KIRKLEES METROPOLITAN COUNCIL INVESTMENT & REGENERATION SERVICE

DELEGATED DECISION TO DETERMINE APPLICATIONS FOR CONSENT, AGREEMENT OR APPROVAL REQUIRED BY CONDITION

Reference No:	2025/44/92614/E
Site Address:	Dixon Hall And Co Ltd, Grafton Street, Batley, WF17 6AR
Description:	Discharge of details reserved by conditions 4 (noise), 10 (delivery management plan) on previous permission 2025/91841 for variation of condition 2 (plans and specifications) on previous permission 2024/93177 for change of use from office building to residential apartments and associated alterations
Recommending Officer:	Edward Cheseldine

2025/92614 - Dixon Hall And Co Ltd, Grafton Street, Batley, WF17 6AR

Figure 2 – Measurement Locations and Site Surroundings

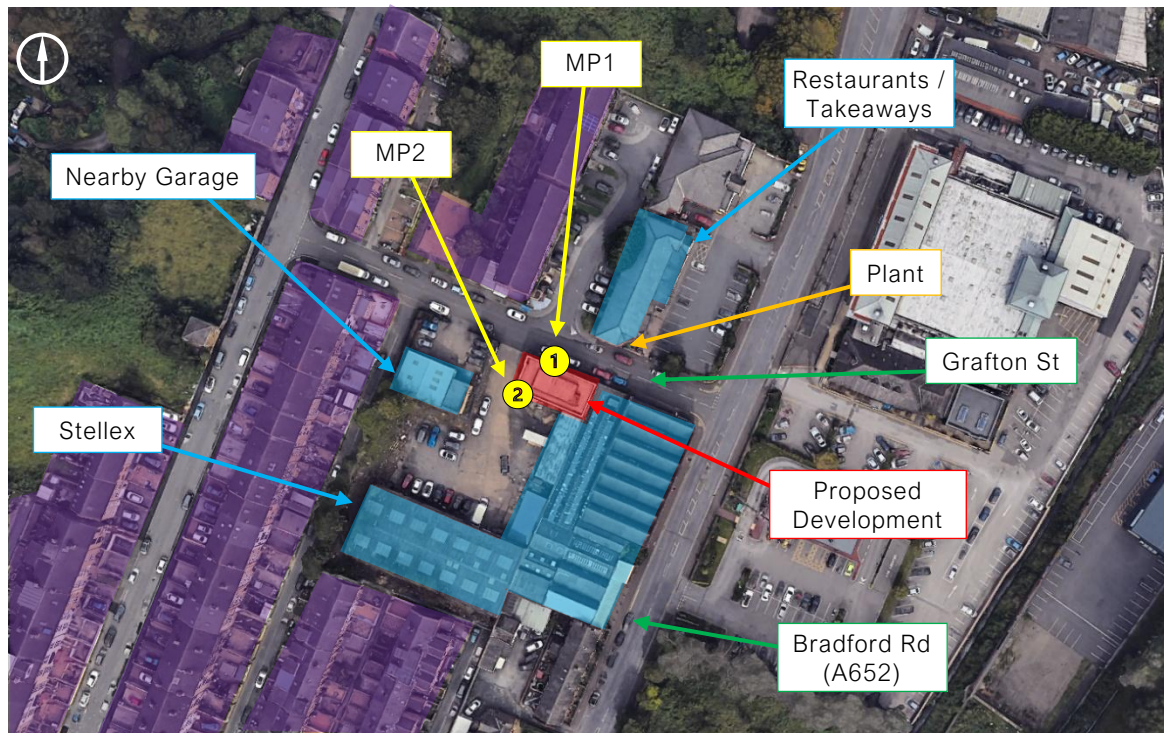
An environmental noise survey was undertaken between the 7th and the 9th of May 2025 from two measurement positions (MPs) as shown in figure 2 and a summary of the findings is given in table 2. The report considers the neighbouring acoustic climate referencing the motor garage, restaurants/takeaways and the applicants adjoining commercial/light industrial premises. Comment is made that during site visits, noise levels within the building were not considered to be significantly influenced by the surrounding commercial activities with occasional operational activity, such as deliveries, observed at the rear of the site.

KC Environmental Health have reviewed the submitted information and confirmed the details were suitable for the discharge of the condition. The condition can be discharged providing the development is constructed in accordance with the details and mitigation set out and retained in perpetuity.

Figure 3 – Façade Allocation – All Floors

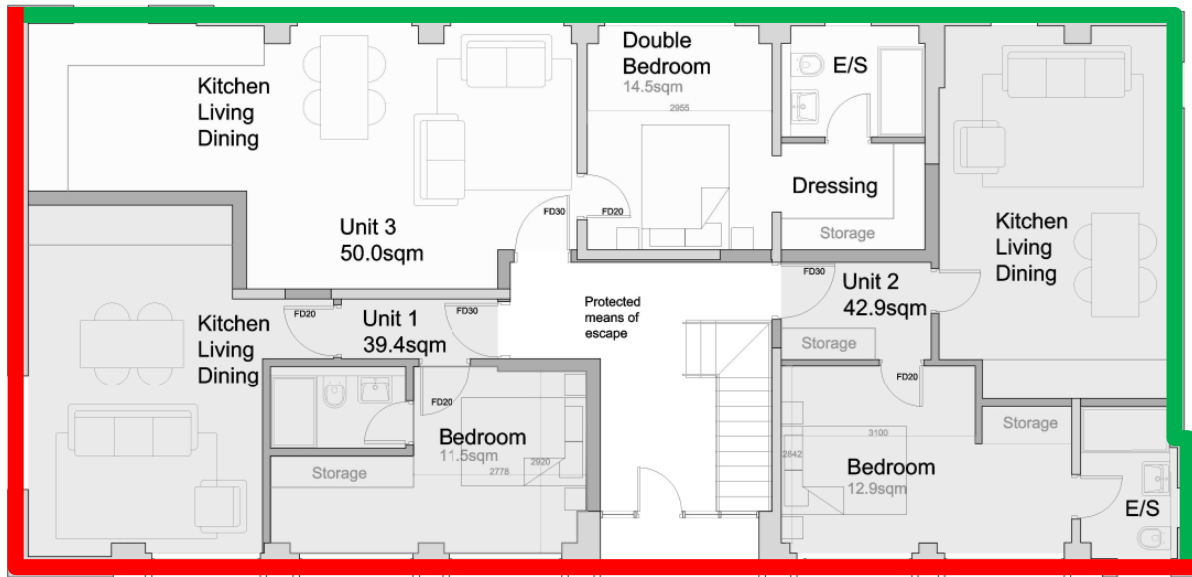
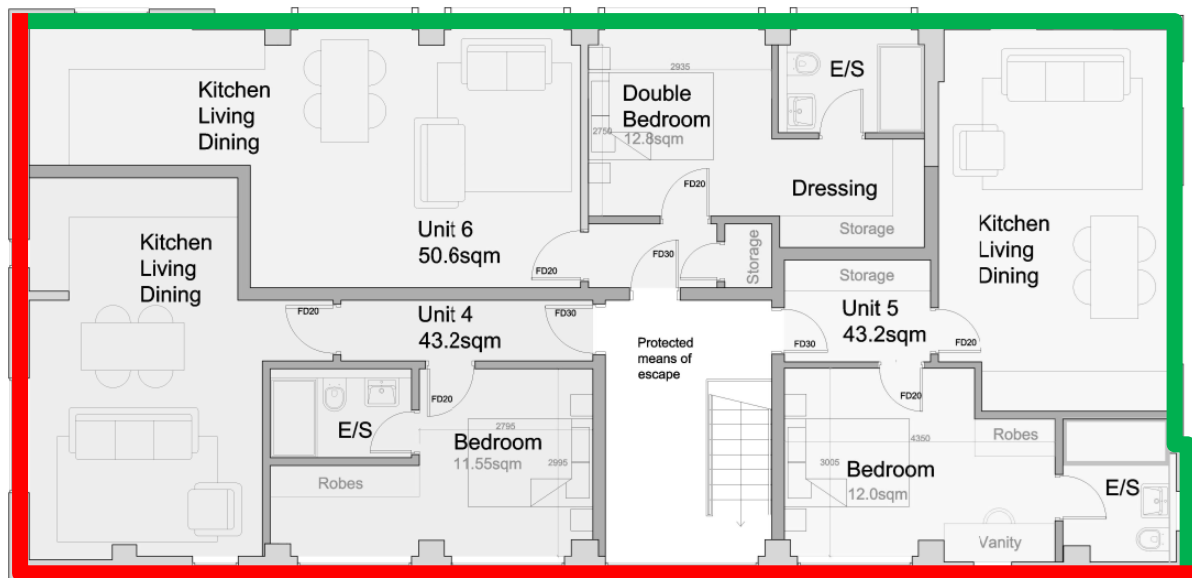
Aside from traffic noise originating from the adjacent road network, no notable noise emissions were detected at the front of the site. In order to meet with the internal requirements of BS8233, glazing and ventilation is specified dependent on the façade and this is shown in colour coded format in figure 3. The specification is given in table 4.
